Matthew Rosel - Submission Details

Submission for Job: #6010 SSD 6010 - One Residential Building (Student Accommodation) within Darling Drive Plot

Site: #2824 SICEEP Site, The Haymarket; Darling Drive, Sydney

29 July 2013

SHADOW DIAGRAMS: PERSPECTIVE, SHOWING THE PEAK, WINTER SOLSTICE

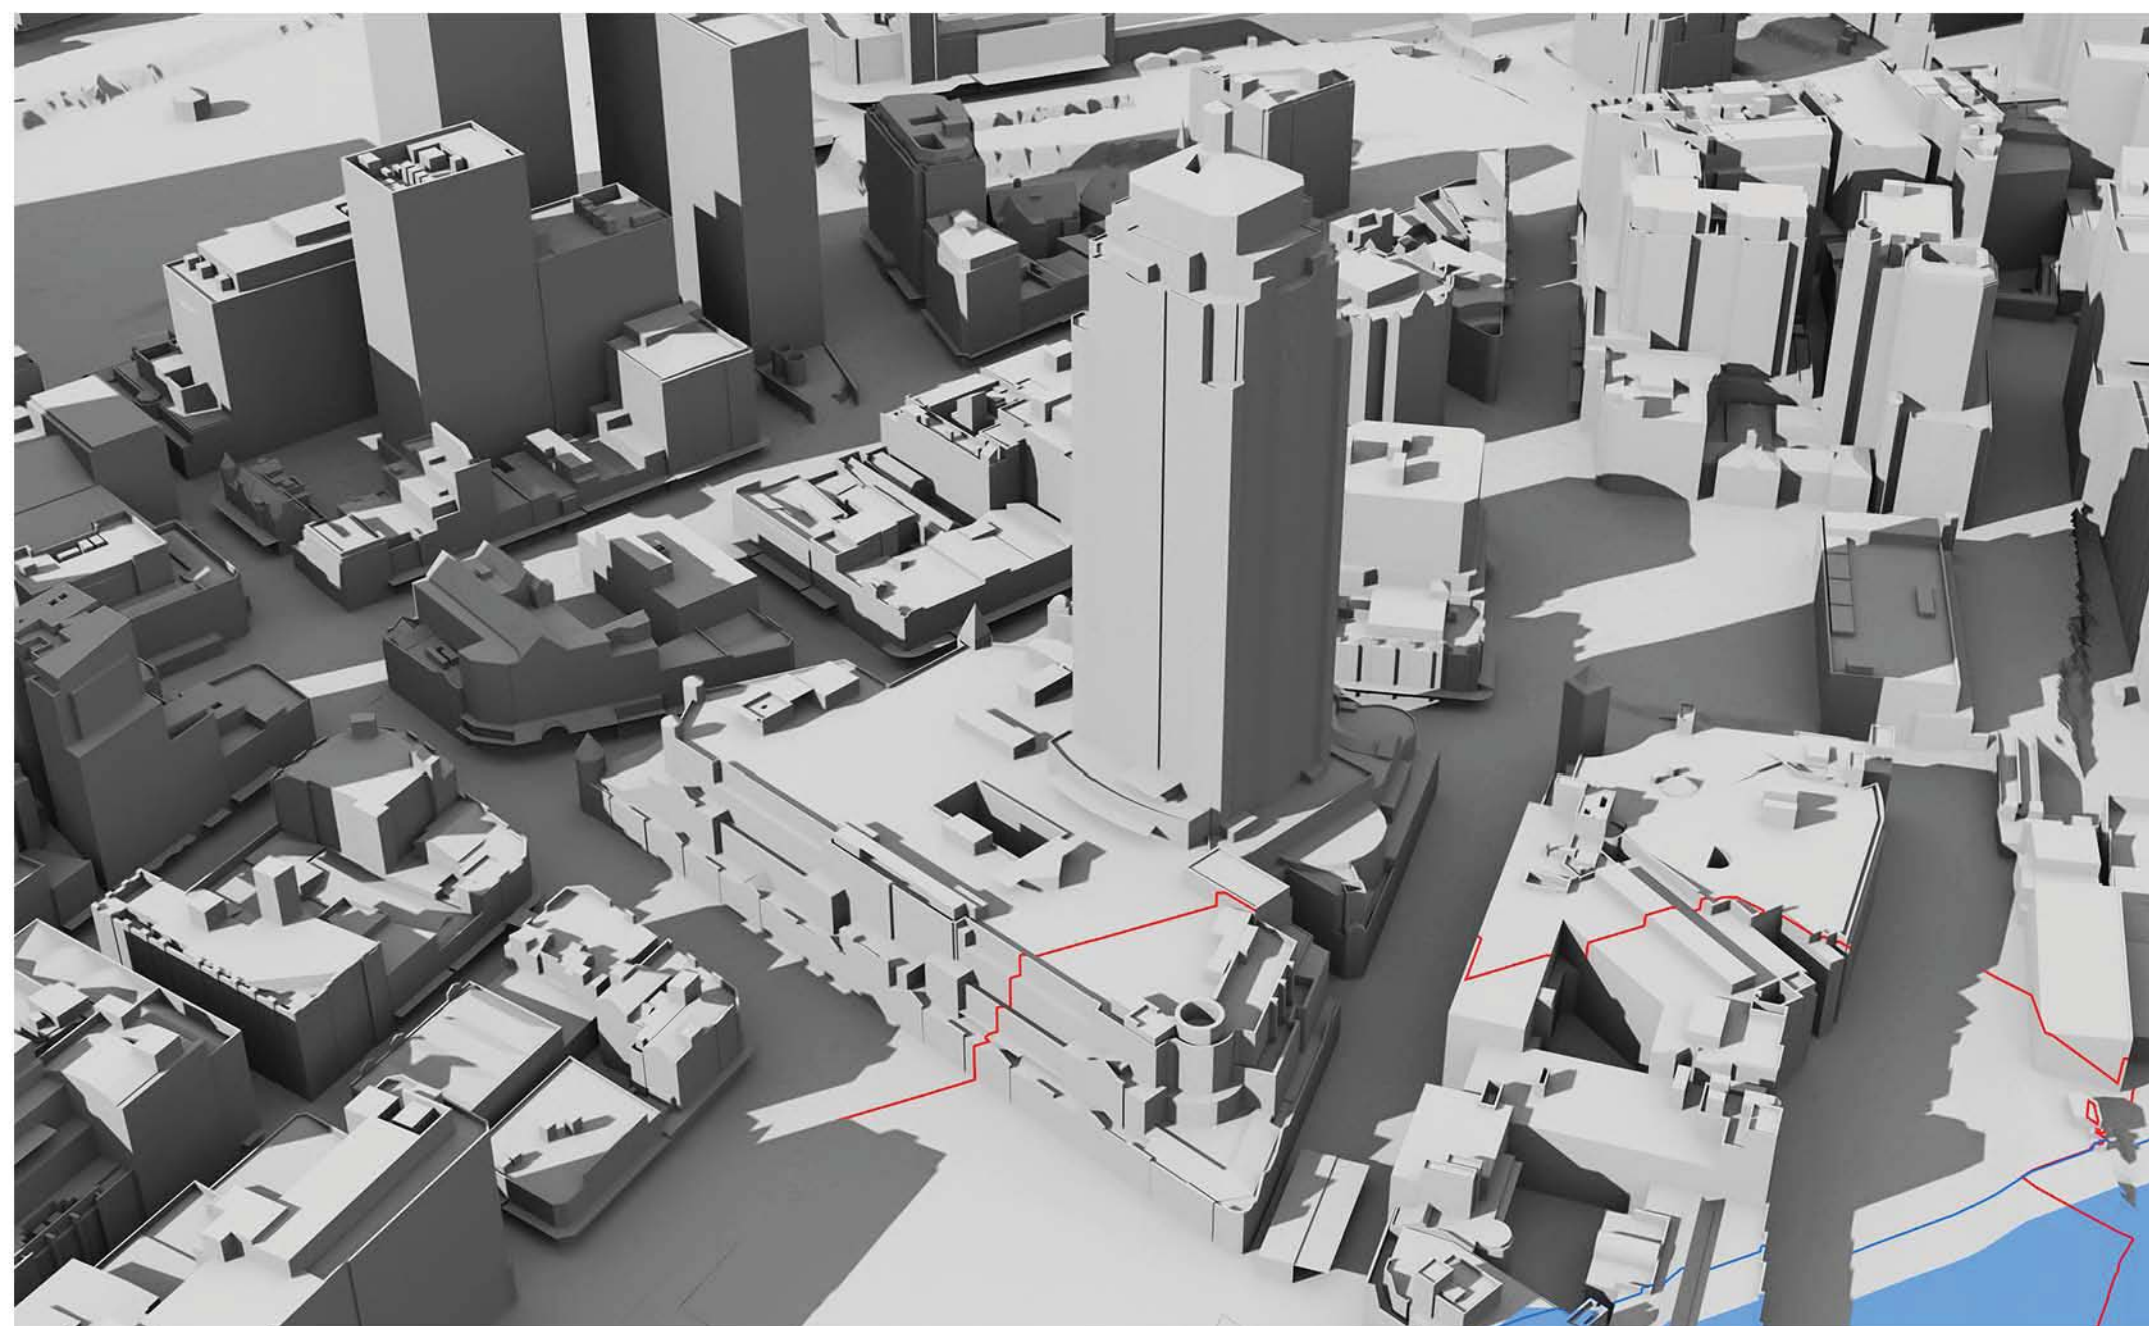
At 9am, 10am and 11am the west façade is totally in shadow due to other parts of The Peak building itself.

At 12pm there is still substantial existing shadowing on the west façade caused by the irregular shape of the west facade.

At 1pm the existing shadowing has been substantially removed, but not totally removed.

It can be concluded that some single aspect apartments on the west façade and some south-west dual aspect corner apartments currently receive less than 2 hours direct sunlight to habitable rooms and 50% of the private open space between 9am and 3pm on 21 June.

By 2pm the existing shadowing has been totally removed, but that is too late to achieve two hours of direct sunlight before 3pm.

At 9am, 10am and 11am the west façade is totally in shadow due to other parts of The Peak building itself.

At 12pm there is still substantial existing shadowing on the west façade caused by the irregular shape of the west facade.

At 1pm the existing shadowing has been substantially, although not entirely, removed. However, overshadowing of lower levels of the west façade by the concept proposal parameter plan shadows for the N,NE and SE plots has already started.

By 2pm the existing shadowing has been totally removed. However, overshadowing of the west façade by the SSDA4 and SSDA5 buildings has appeared and risen further up the west façade than the concept proposal parameter plan shadows for the N,NE and SE plots, which is still present.

At 3pm, the proponent states correctly that 45-45% of the western façade is overshadowed by the SSDA4 and SSDA5 buildings.

It can be concluded that, as a result of combination of the proposed development with existing shadowing of the west façade, some single aspect apartments on the west façade and the south-west dual aspect corner apartments which currently receive less than 2 hours direct sunlight to habitable rooms and 50% of the private open space between 9am and 3pm on 21 June will suffer additional overshadowing. It is beyond our skills to count the number of such apartments. We note that the proponent has made no attempt to do so.
